**WEST SUSSEX COUNTY COUNCIL
STRATEGIC PLANNING CONSULTATION**

DATE: 27/04/2017

SUBJECT: BR/74/17/PL - Conversion of the ground floor to create 2 No. self-contained flats.

The Kindergarten, 86, Annandale Avenue, Bognor Regis, West Sussex, PO21 2EX

Site & Block Plan.

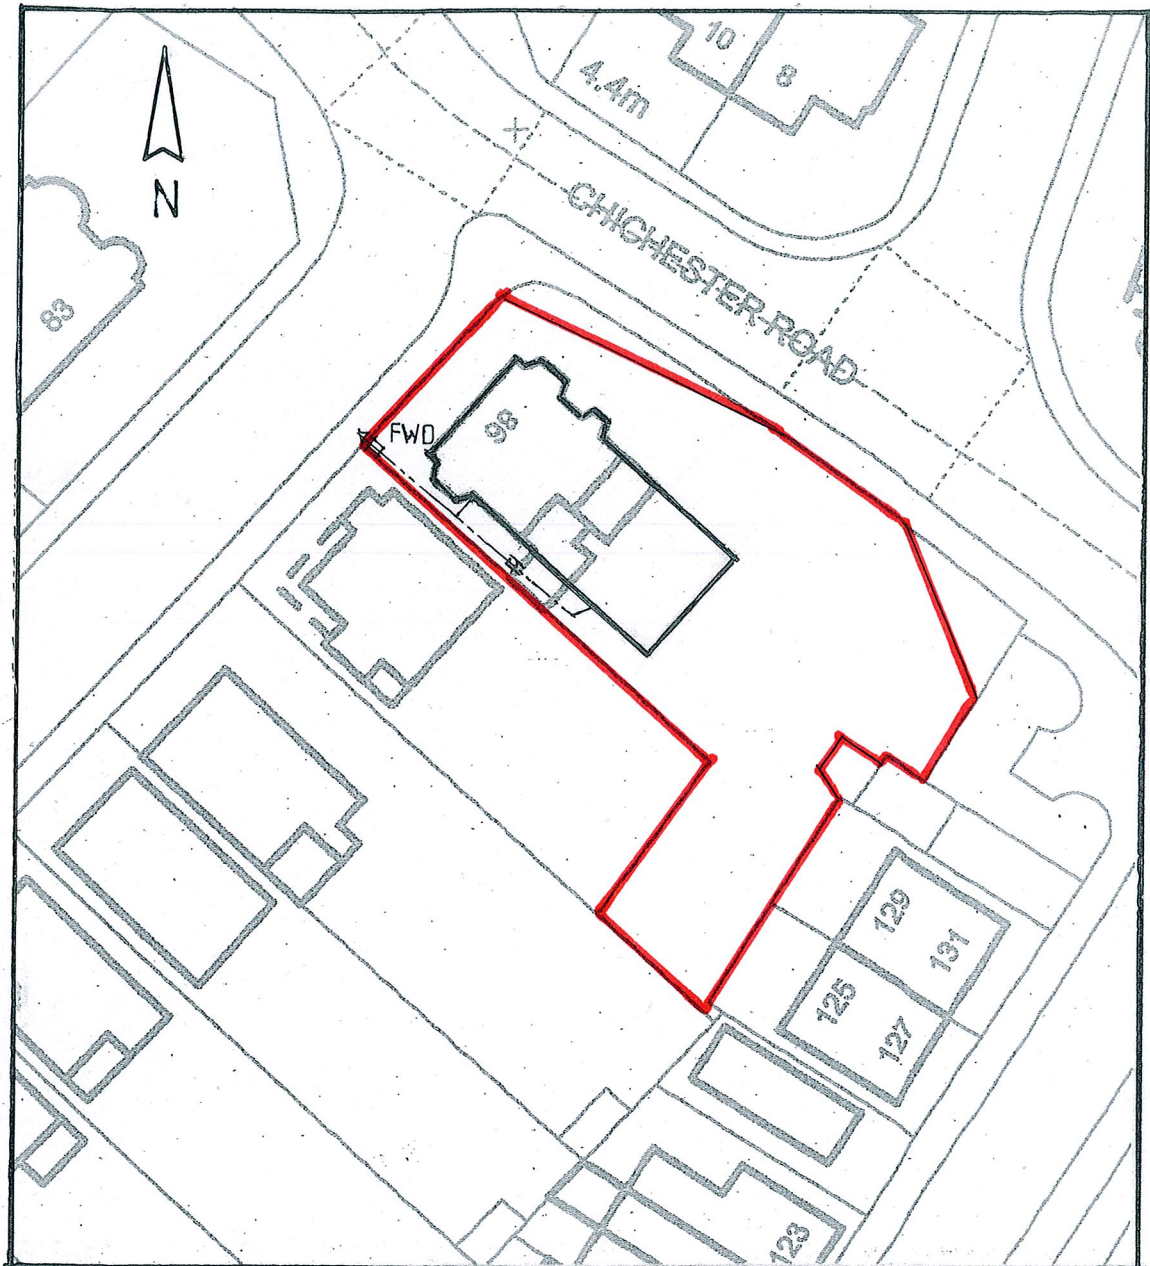
No off street parking details have been provided. The applicant should clarify the proposed parking arrangements and whether the existing off street parking area will be utilised. If a nil car parking provision is proposed then the existing dropped kerb should be reinstated. Considering the existing use as children's nursery and the on street parking at
